From: [REDACTED]
Sent: 26 March 2019 17:55
To: Simon Davis <Simon.Davis@arun.gov.uk>
Cc: [REDACTED]
Subject: Re: BN/50/18/PL The Fallows

Drainage advice received today in response to your email is that:

Drawing 23B – SW Drainage Plan
Scale 1:200 @ A3

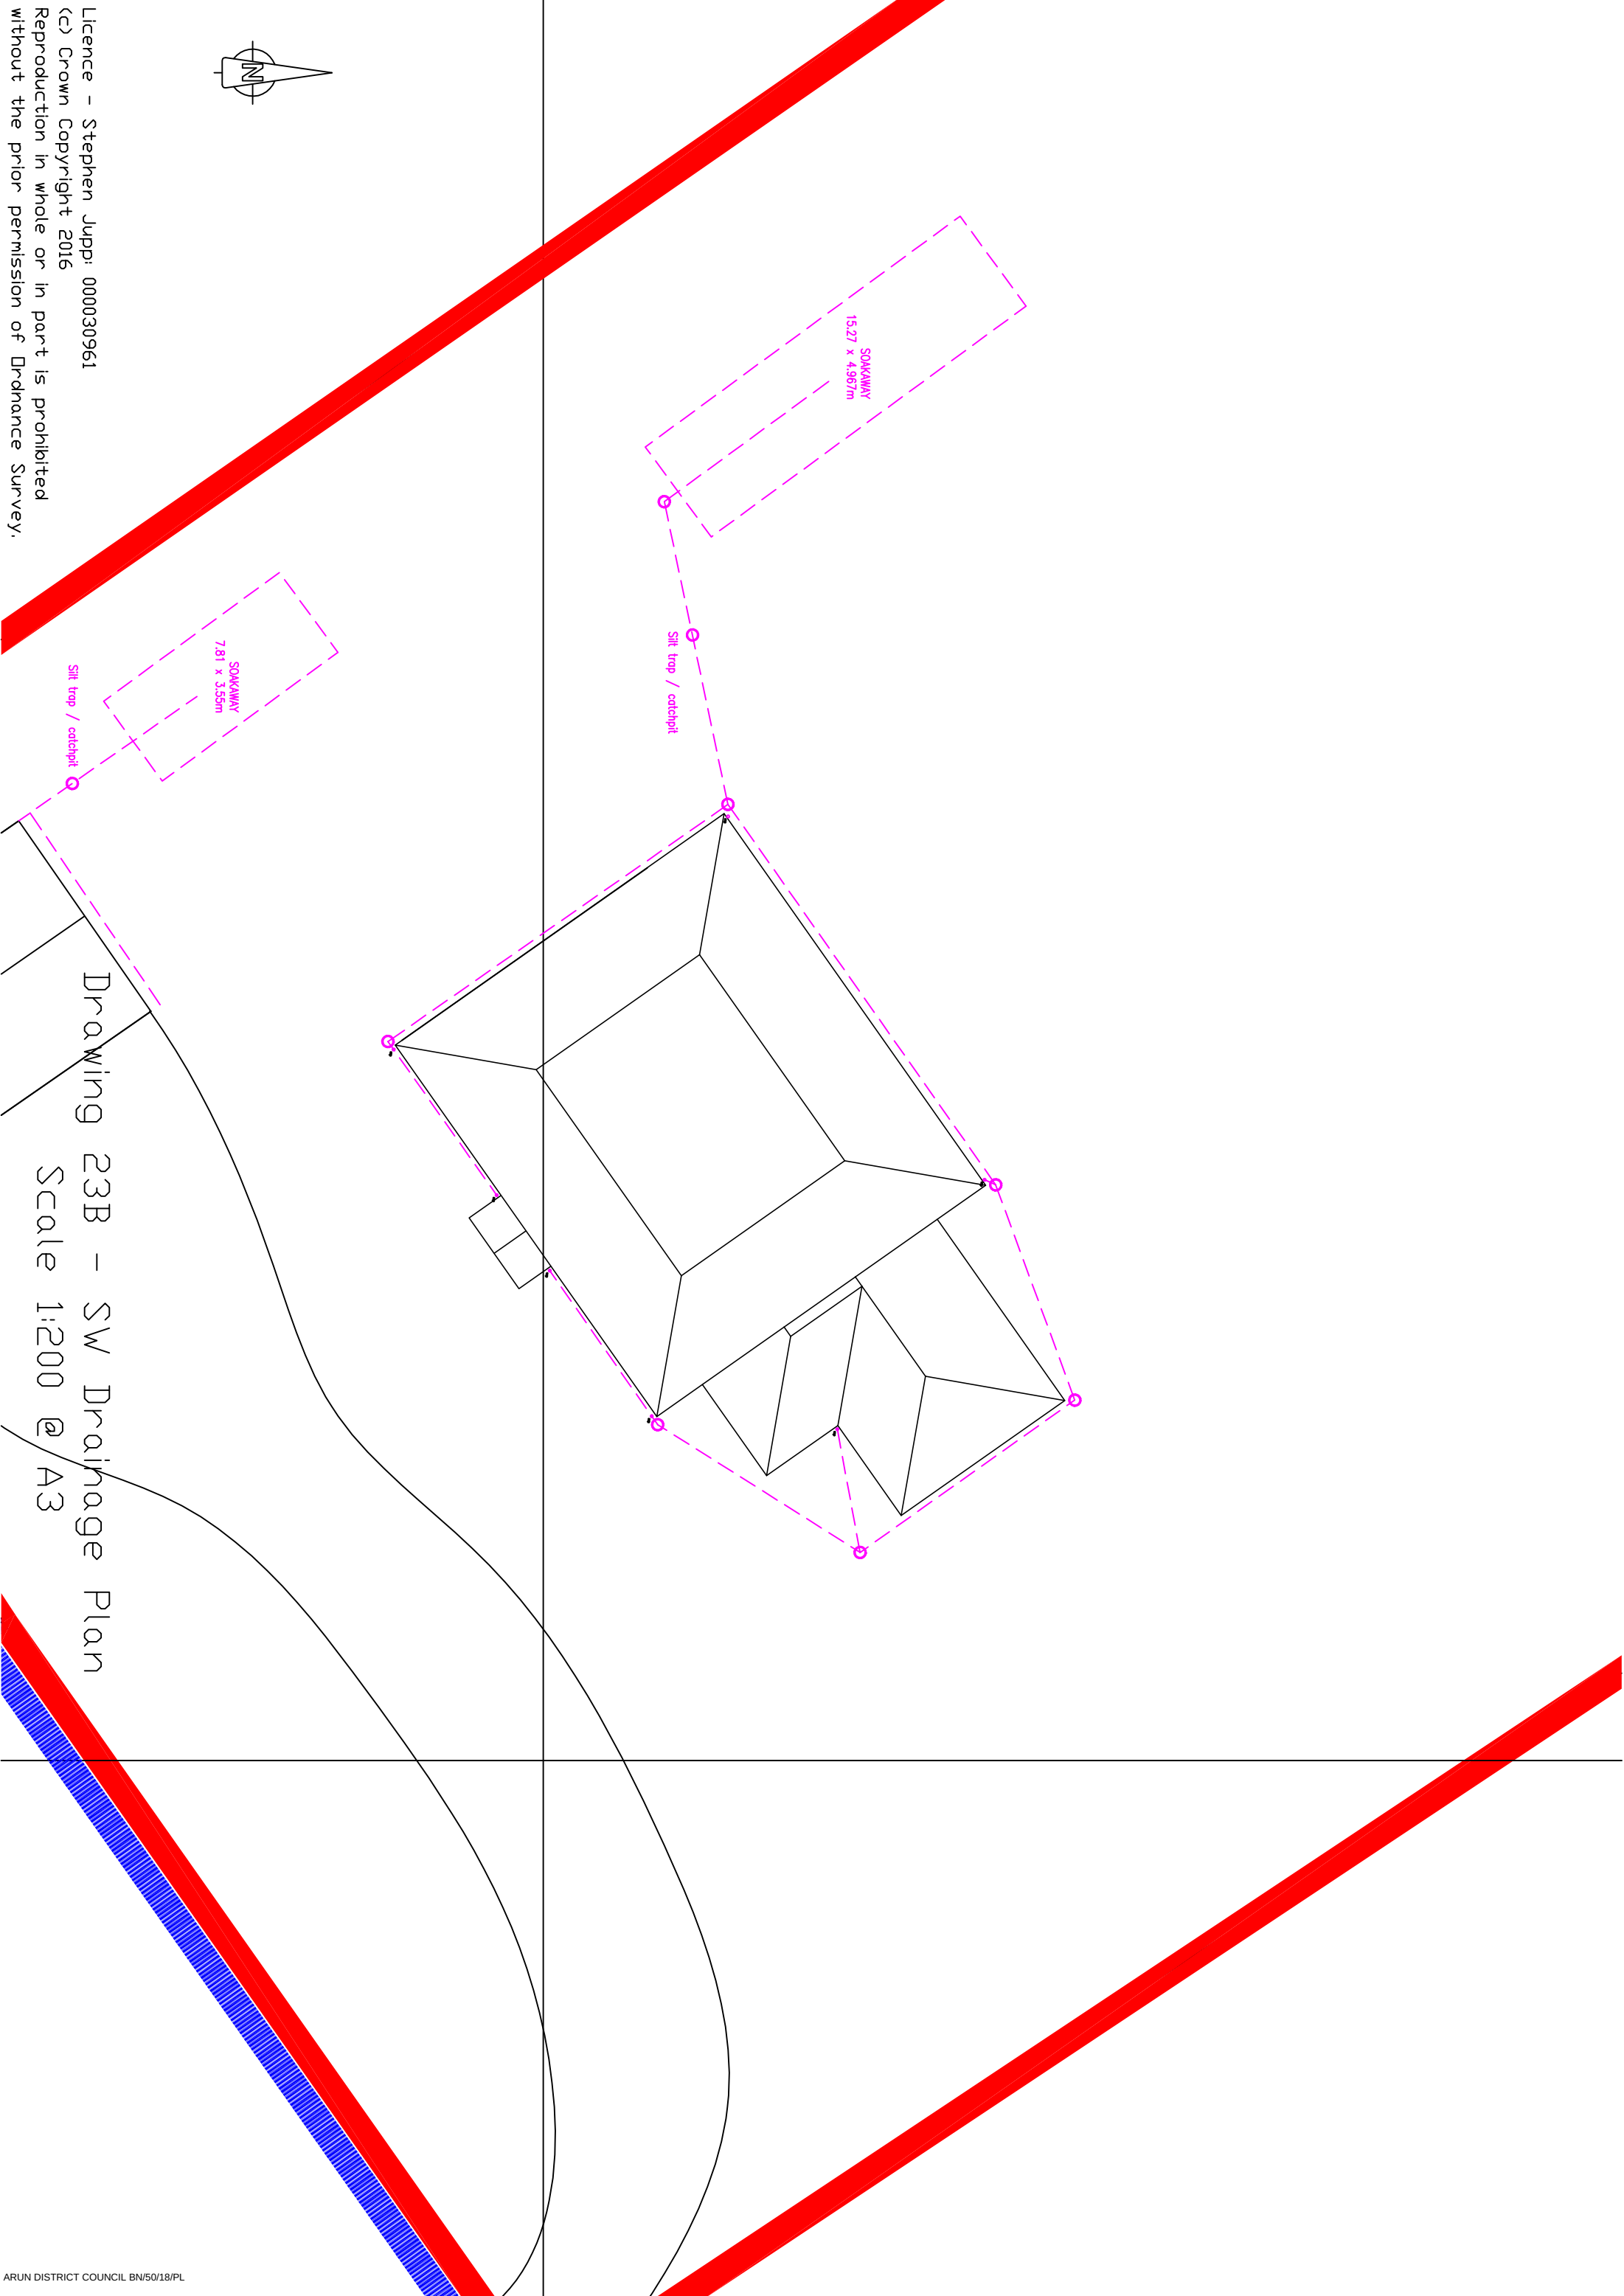
“It is unclear if the crates proposed would be suitable for such shallow cover depths. Furthermore, as detailed on the soakaway detail plans 100mm sand is required above the crates, this leaves only 100mm topsoil which wouldn't be sufficient to support grass growth. Shallower crates are available and should be looked at.

Furthermore, a location plan showing the soakaways and upstream pipe work including catchpits needs to be provided. This plan needs to include invert and cover levels.

Hi Simon
Thank you.
I'll get Phill at Archibald Shaw to make amendments as necessary.
